# DRAINAGE MEMO

## BLACK FOREST MEADOWS

County Fil No.: VA211

September 15, 2021

Black Forest Meadows Outdoor Wedding Venue Concept Plan April 7, 2021

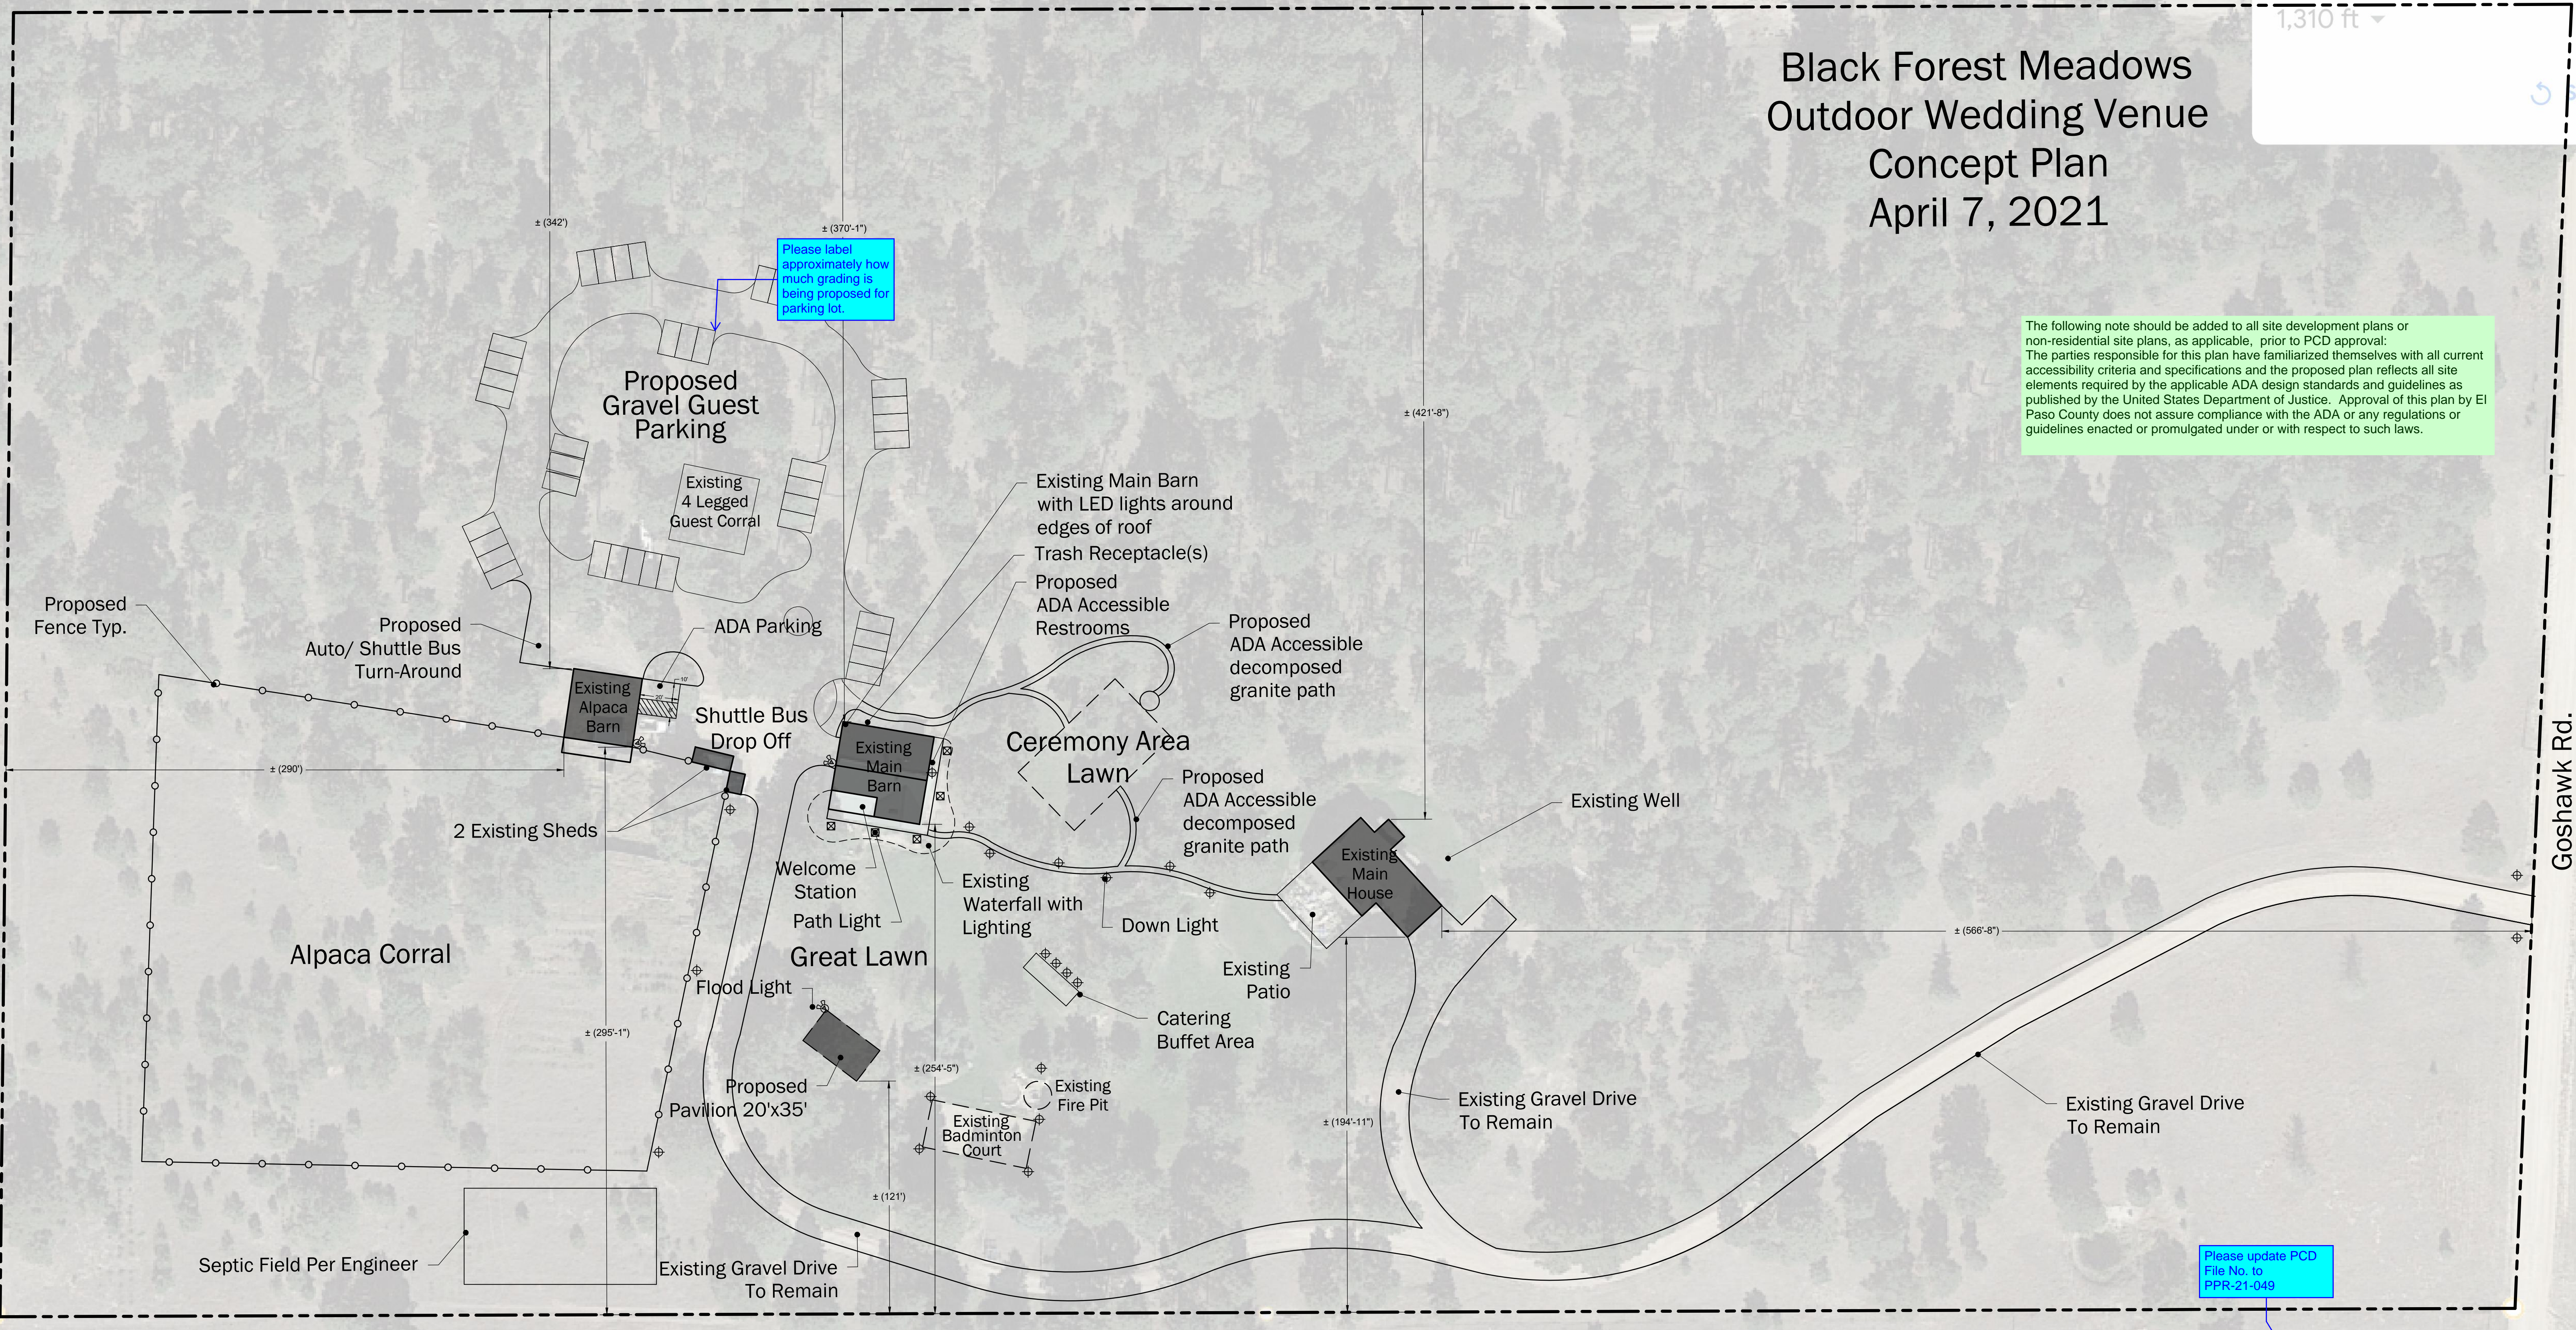
Please reiterate how much grading is being proposed with the inclusion of the parking lot.
